From: Christina Stacey <cstacey@portlandmaine.gov>
Date: March 28, 2016 7:51:15 AM EDT
To: Justin Van Soest <justinvansoest@gmail.com>
Subject: Re: Van Soest Property Meeting

Attached top this email are PDF's indicating what we would submit for permitting to the City. The are more drawings for the permit, but I have included here what I believe is most relevant for the administrative waiver and the "rear" property setback we discussed. As you indicated, the proposed deck structures would remain in excess of 16' of the property line.

SITE PLAN DETAIL

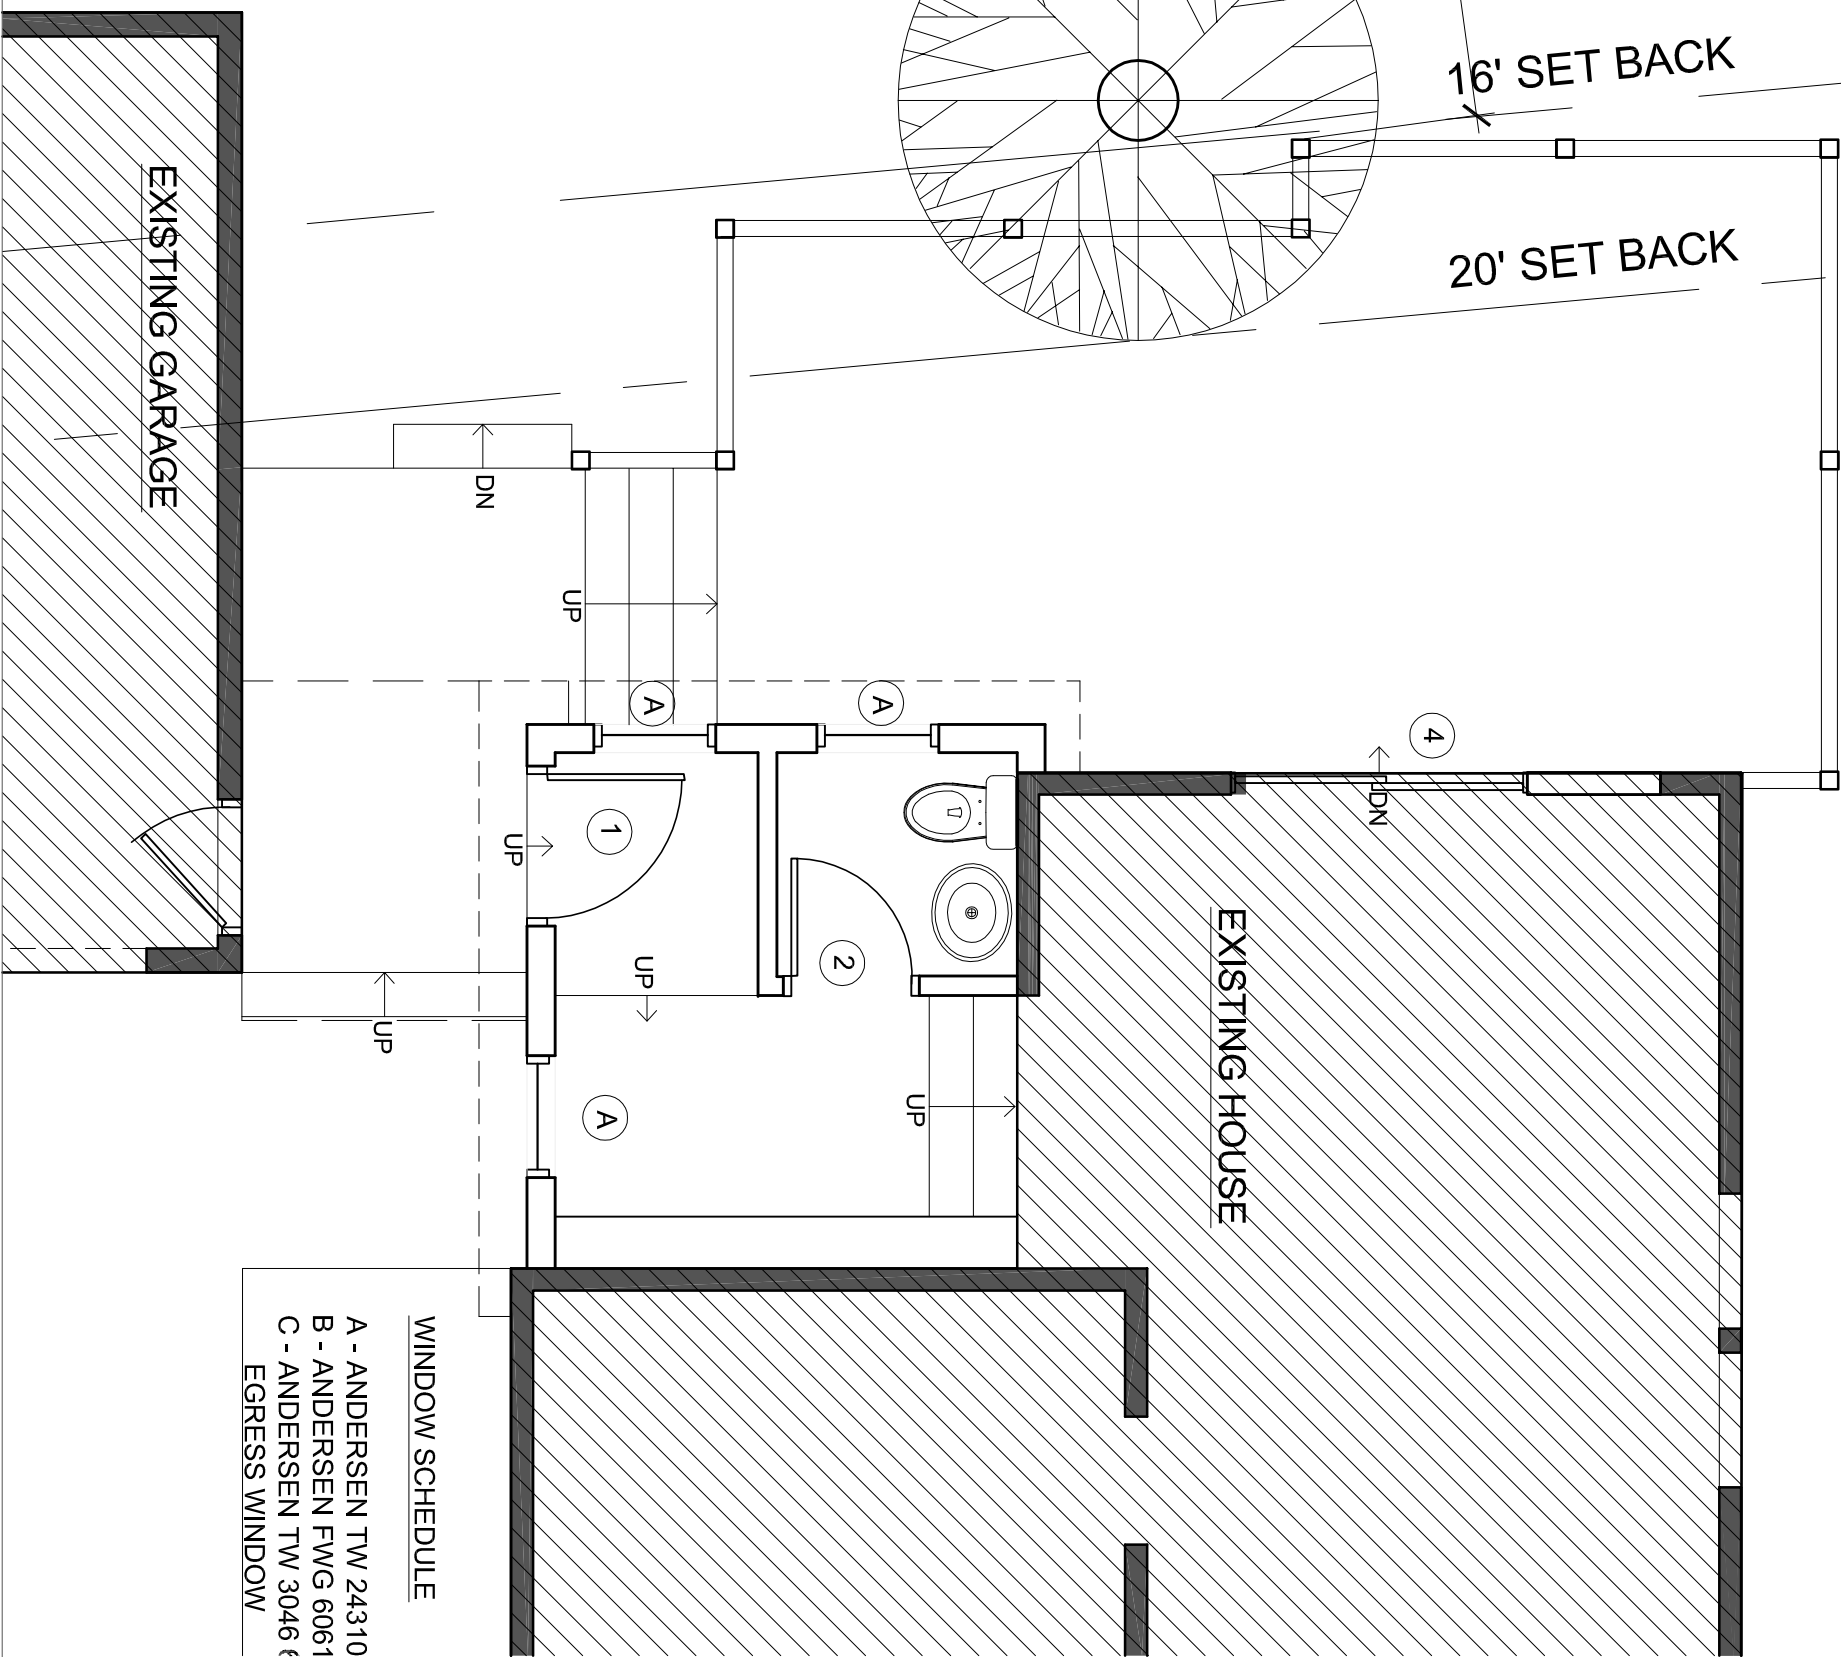
Yes, I was referring to the steps that go from the large deck down to a lower deck(?) that will abut the garage.

The other new structures (bathroom and the smaller stoop/deck) are going to be at least 20' from the rear line, correct? If so, I think you should be all set for zoning. I don't think there is any need for us to meet; at this point it is a matter of submitting your permit application and going through the process!

Attached is a modified drawing showing the 20' setback as well as the 16'. I think this answers your question? The stoop and lower deck are outside 20'.

When drawing I considered all the deck structures (except for what is right in front of back door) part of the "deck" and so had in mind the 16' limitation only. However, the stair and surface below it should be 20" away.
